THE TRAILS AT ASPEN RIDGE FILING NO.5

A SUBDIVISION OF TRACT H OF THE TRAILS AT ASPEN RIDGE FILING NO.3 LOCATED IN THE WEST 1/2 OF SECTION 9, TOWNSHIP 15 SOUTH, RANGE 65 WEST OF THE 6TH P.M. EL PASO COUNTY, COLORADO
SHEET 1 OF 3

DATE: 3/10/22
SHEET 1 OF 3

THE TRAILS AT ASPEN RIDGE FILING NO.5
A SUBDIVISION OF TRACT H OF THE TRAILS AT ASPEN RIDGE FILING NO.3 LOCATED IN THE WEST 1/2 OF SECTION 9,
TOWNSHIP 15 SOUTH, RANGE 65 WEST OF THE 6TH P.M. EL PASO COUNTY, COLORADO
SHEET 1 OF 3

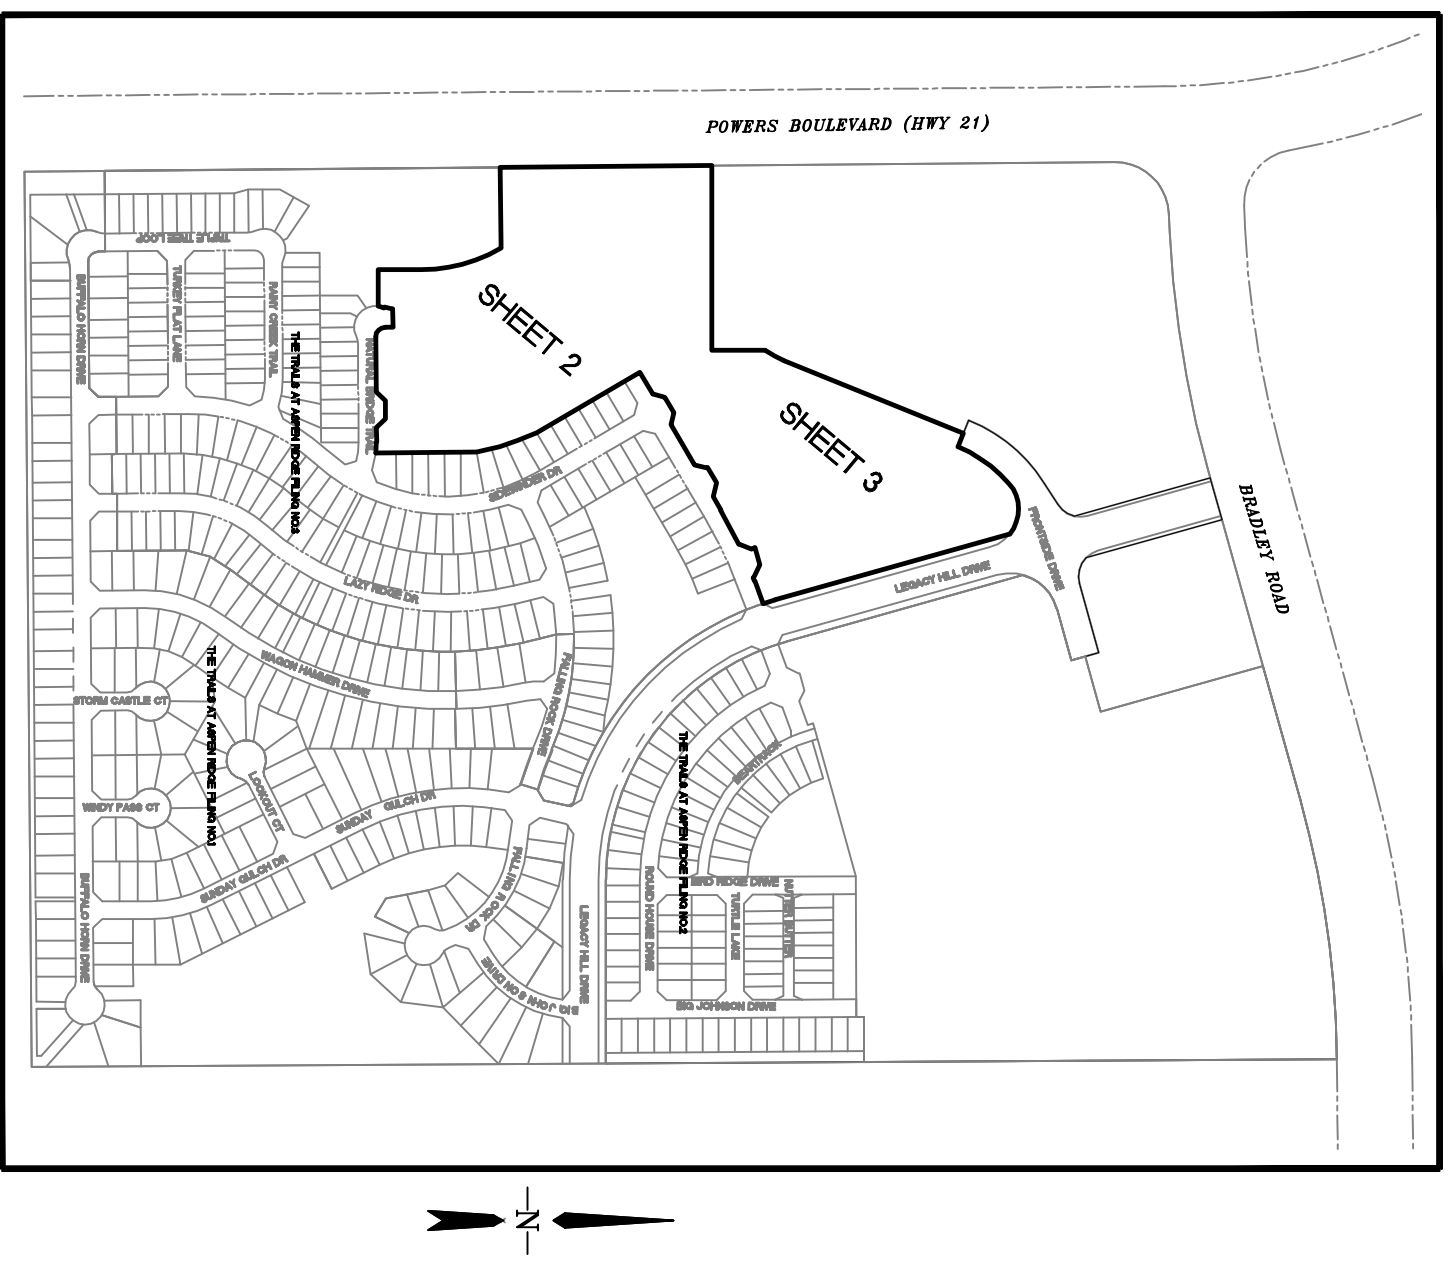
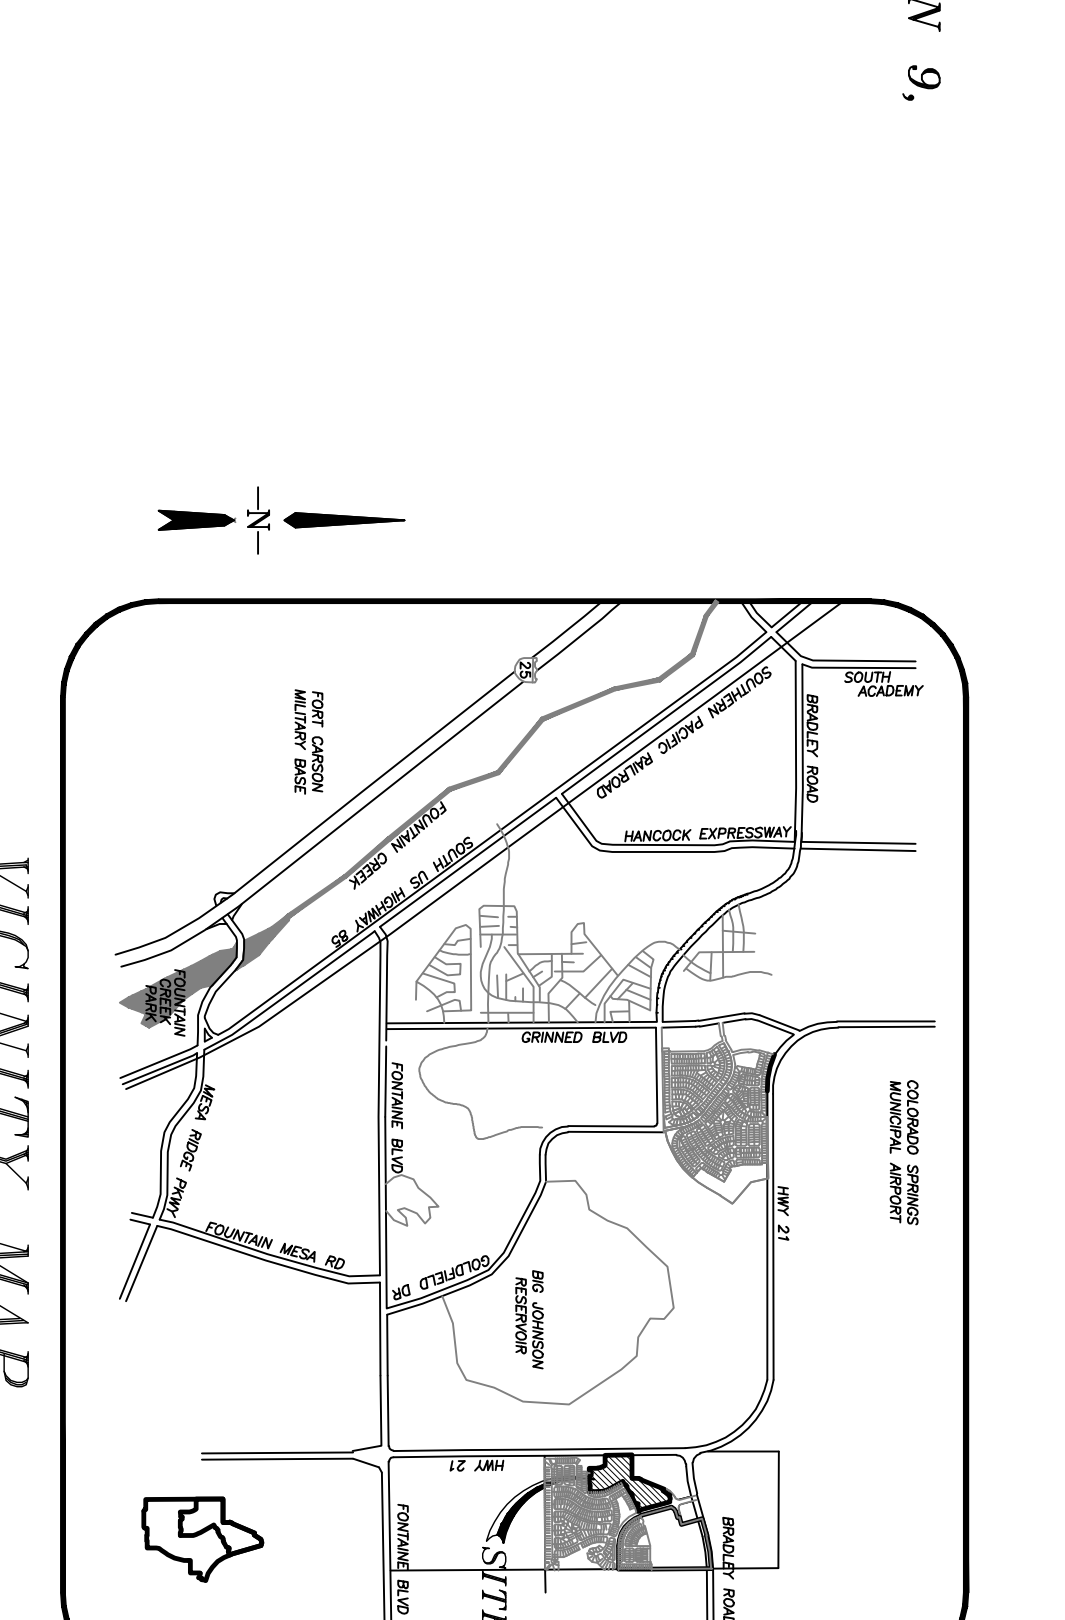
Soils & geology report indicates geologic hazards on the property and mitigation required. Please depict geologic hazards on the plat. Please include the soils & geology note:

Soil and Geology Conditions:
Geologic Hazard Note-Final Plat: (to be customized based upon the individual circumstances)
The following lots have been found to be impacted by geologic hazards. Mitigation measures and a map of the hazard area can be found in the report (Title of Report, generally from the Preliminary Plan file) by (author of the report) (date of report) in file (name of file and file number) available at the El Paso County Planning and Community Development Department:
•Downslope Creep: (name lots or location of area)
•Rockfall Source: (name lots or location of area)
•Rockfall Runout Zone: (name lots or location of area)
•Potentially Seasonally High Groundwater: (name lots or location of area)
•Other Hazard:
In Areas of High Groundwater:
Due to high groundwater in the area, all foundations shall incorporate an underground drainage system.

Waterview II Metro District? Please update this note.

Unresolved Review 1 Comment:
Add the following plat note:
- Perimeter drains and sump pumps shall not directly discharge onto public Right-of-Way.

Unresolved Review 1 comment:
Add "PCD File No SF-21-38"
